Rezoning Transportation Analysis

Petition Number: 2023-154

Revision Log:

Date	Description
12-27-23	First Review (JP)
01-24-24	Second Review (JP)

JOB NO.  
**62387**  
SHEET NO.  
**RZ-1**

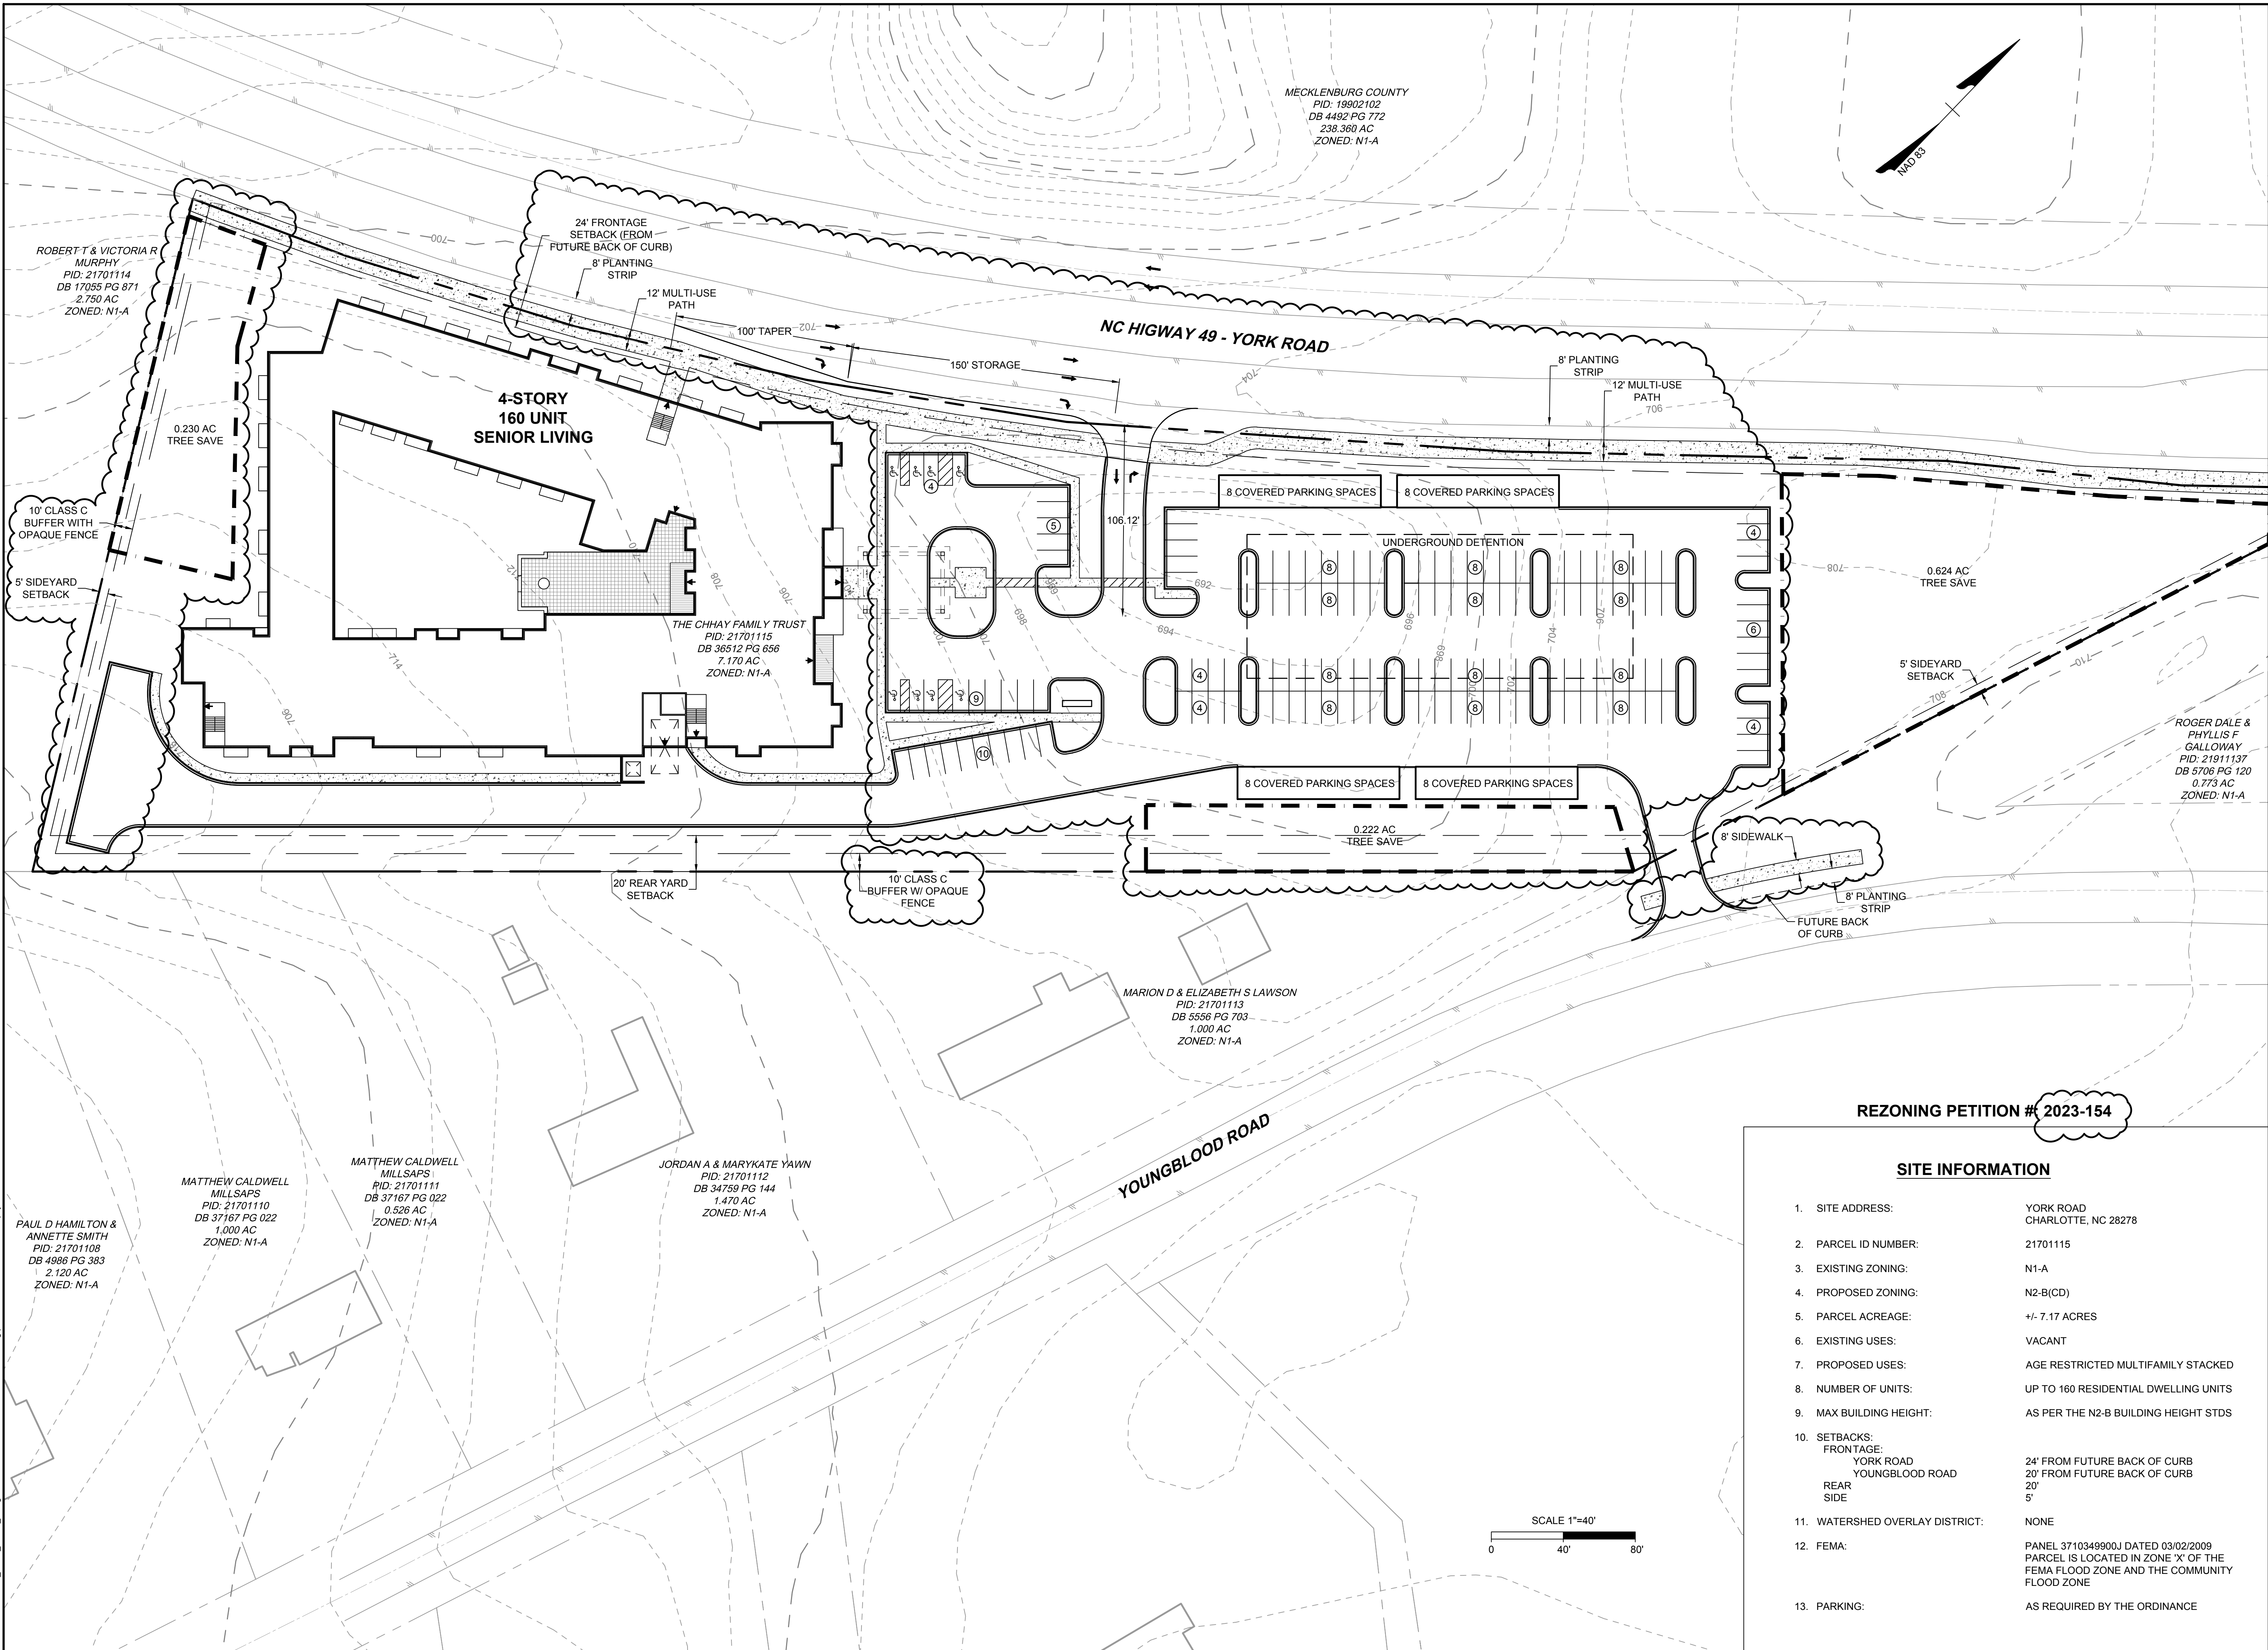
Outstanding Comment 1.24.24: Label and dimension the curb and gutter from the centerline for each road on the site plan.

3. **Outstanding Comment 1.24.24:** The site plan shall label and dimension the right-of-way from the road centerline.
4. **Outstanding Comment 1.24.24:** In coordination with NCDOT, revise site plan and conditional note(s) to show the existing driveway on the east side of Youngblood Road. Align the sites entrance along the centerline of the existing driveway.

- 5. **Outstanding Comment 1.24.24:** Revise site plan and conditional note(s) to commit to restriping a left turn lane into the site off of Youngblood Road.

6. In coordination with NCDOT, revise site plan to remove western most site access.

7. In coordination with NCDOT, revise site plan and conditional note(s) to install a right turn lane on York Road with 150' storage and 100' taper.

8. In coordination with NCDOT, revise site plan and conditional note(s) to provide a 100' internal protected stem.
